DELEGATED DECISION FOR DISCHARGE OF CONDITION A.4 - NOTIFICATION OF A PROPOSED ENLARGEMENT TO DWELLINGHOUSE

Reference no.	2024/HH/93520/E
Site Address	24, Smithy Close, Skelmanthorpe, Huddersfield, HD8 9DQ
Description	The proposal is for erection of single storey rear extension. The extension projects 5.5m beyond the rear wall of the original dwellinghouse. The maximum height of the extension is 3.9m, the height of the eaves of the extension is 2.8m
Recommending Officer	Molly Storer

DISCHARGE OF CONDITION A.4 , SCHEDULE 2, PART 1, CLASS A GENERAL PERMITTED DEVELOPMENT ORDER

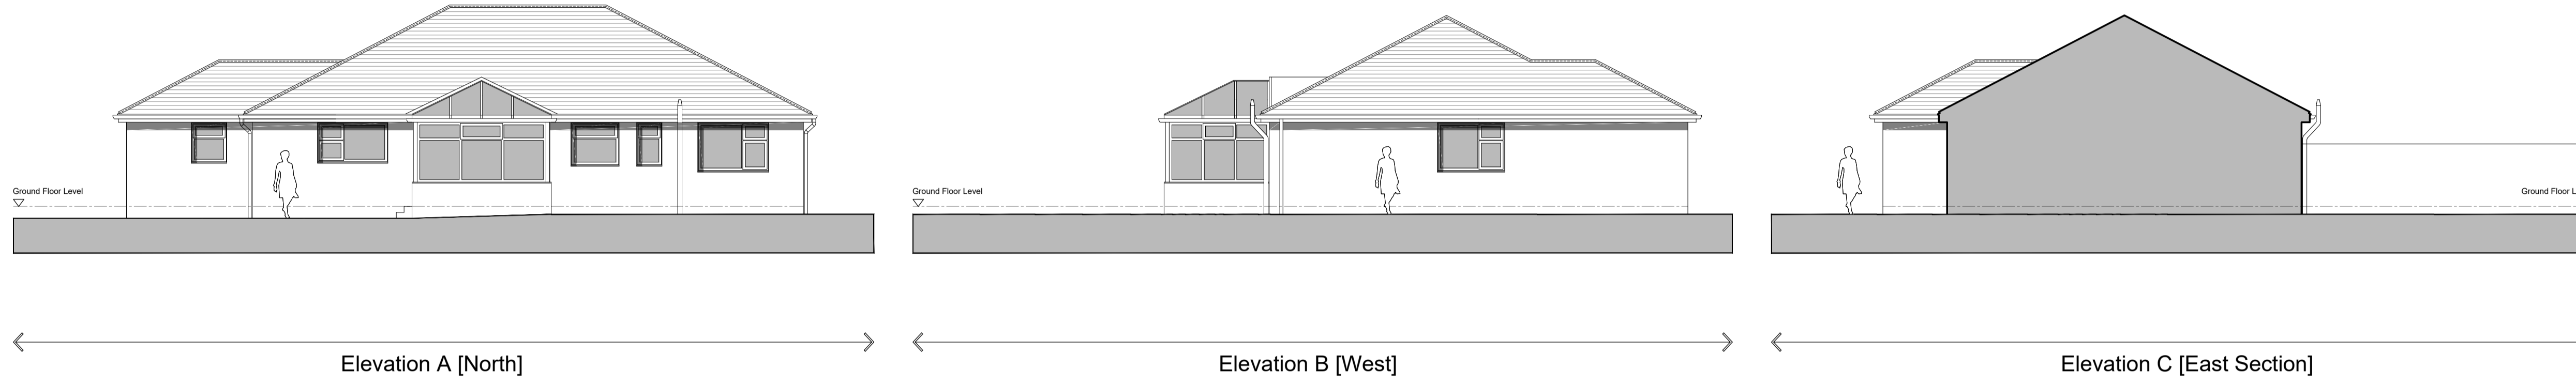
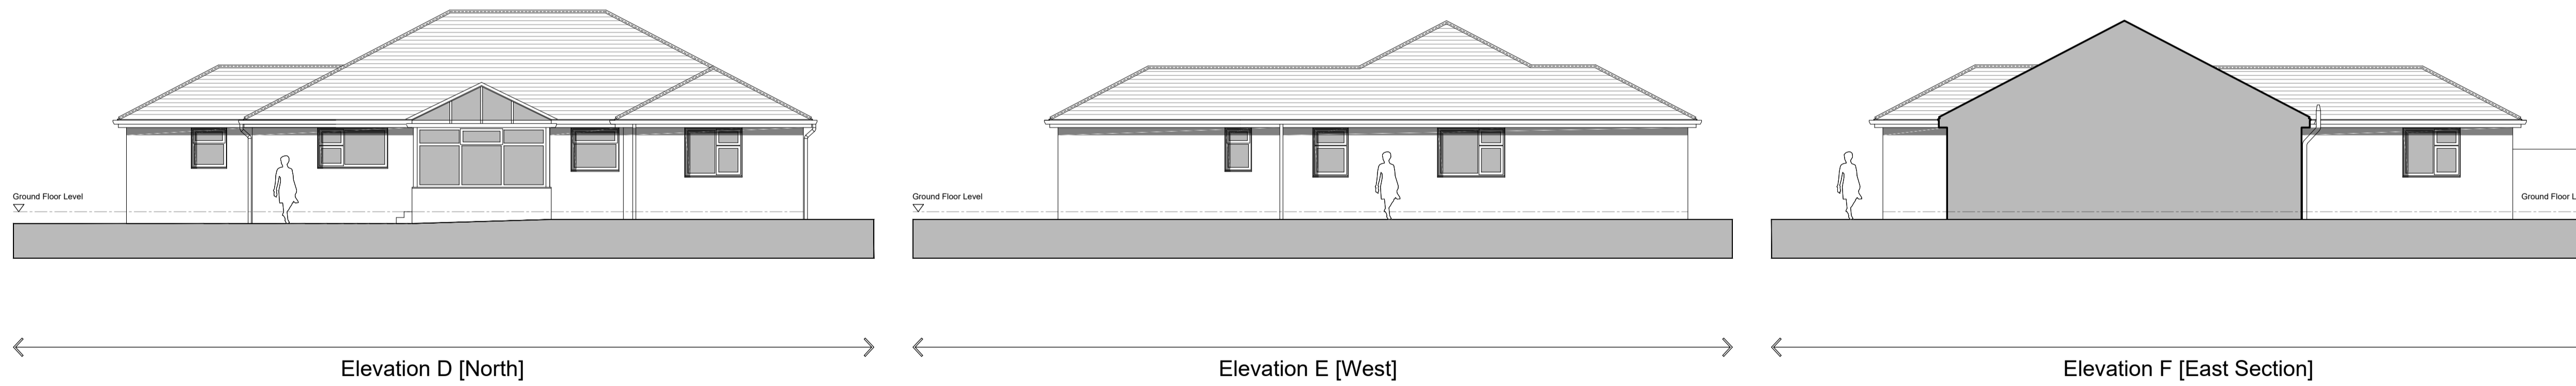
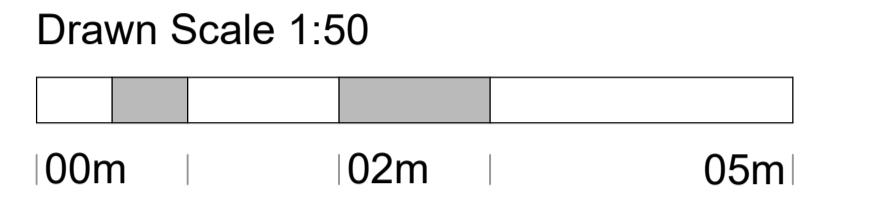
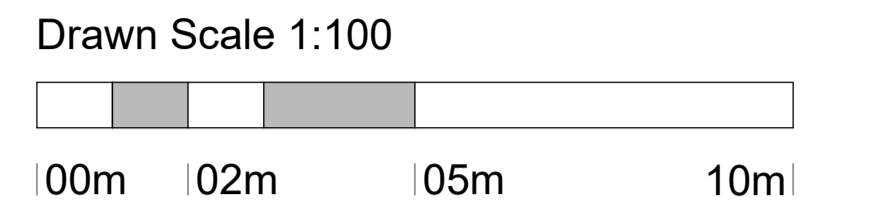
- The slope of the land away from the rear of the property will result in the height of the extension above ground being greater than stated when considered at the extension limit furthest from the property.
- Impact to other properties.

Comments received explained that there was a slope of the land away from the rear of the property which could result in the height of the extension above ground being greater than stated when considered at the extension limit furthest from the property and as a result this could lead to a negative impact to neighbours to the rear.

The agent provided pictures of the site and elevation plans which show there is no significant slope to the rear of the site and in any case a separation distance of over 12m between the extension and the nearest property to the rear. It also shows the maximum overall height from the ground level will be 3.9m.
